Final Plat - Comment Response Letter

Citizen on Constitution  
El Paso County, Colorado

PCD File Number: SF-226

**AKERS DRIVE CD'S – PCD ENGINEERING  
COMMENT RESPONSE**

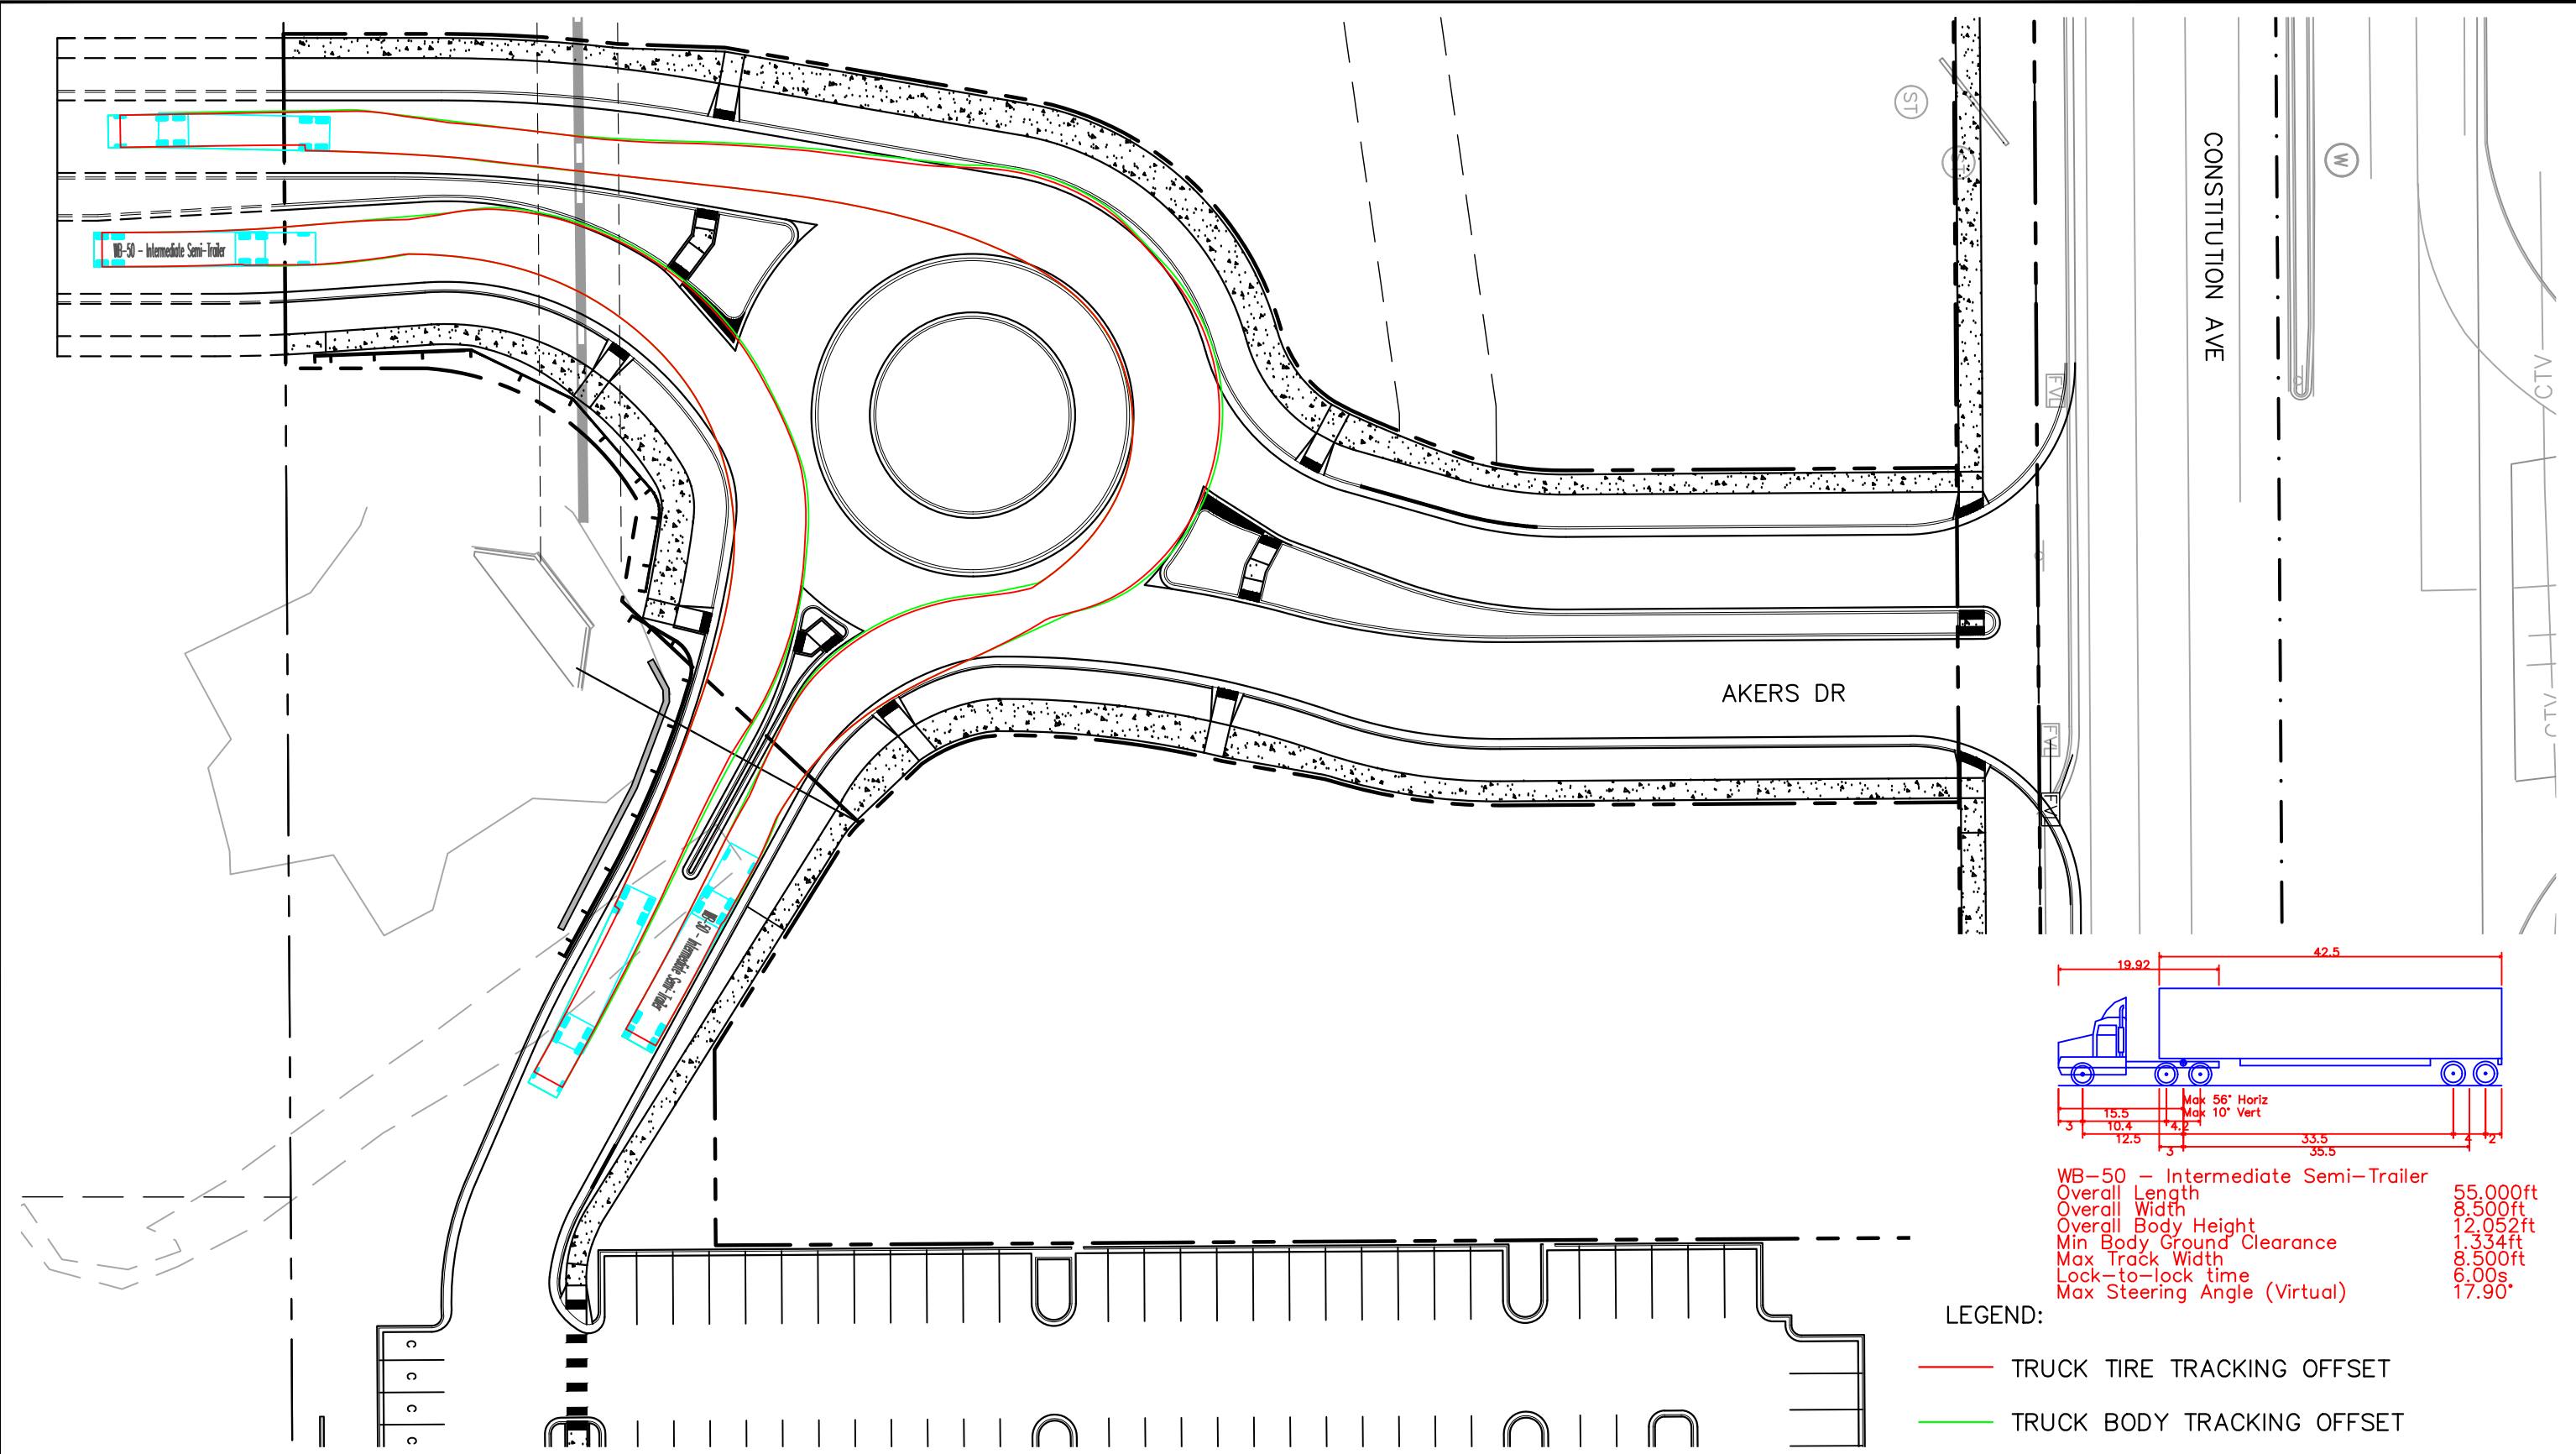
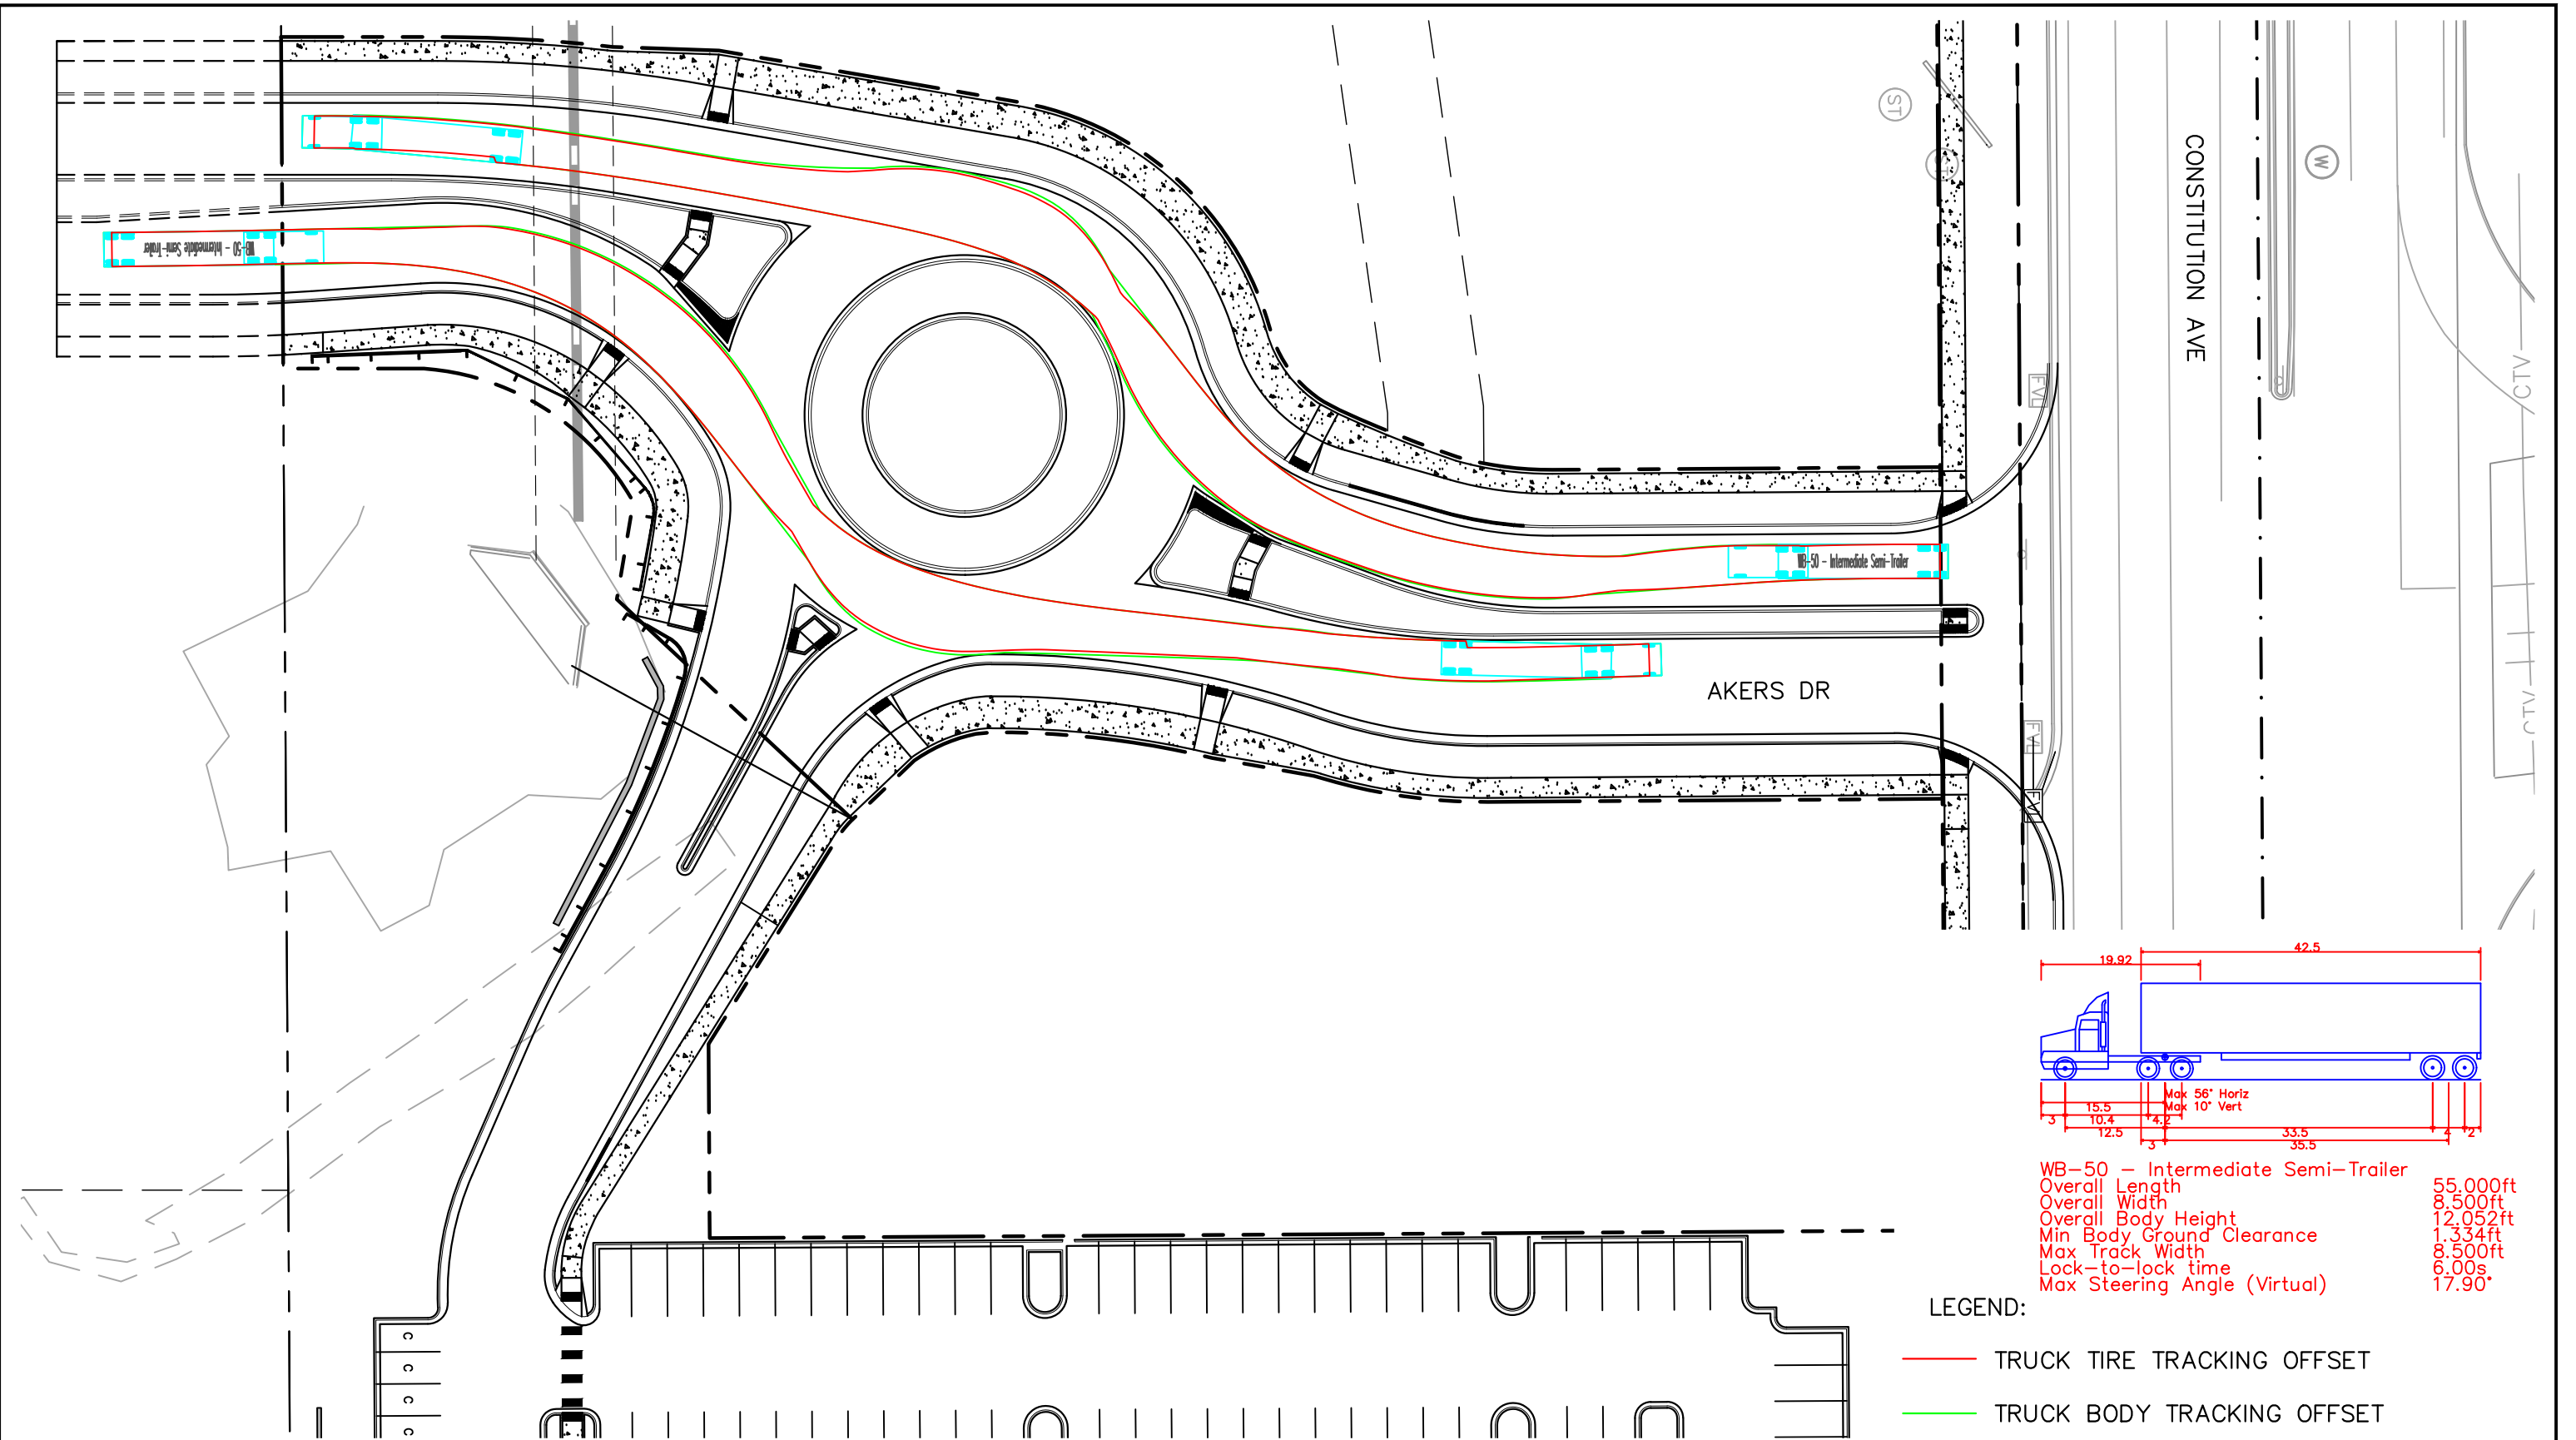
Please revise from snow plow to the WB-50 vehicle

UPDATED TO WB-50 VEHICLE
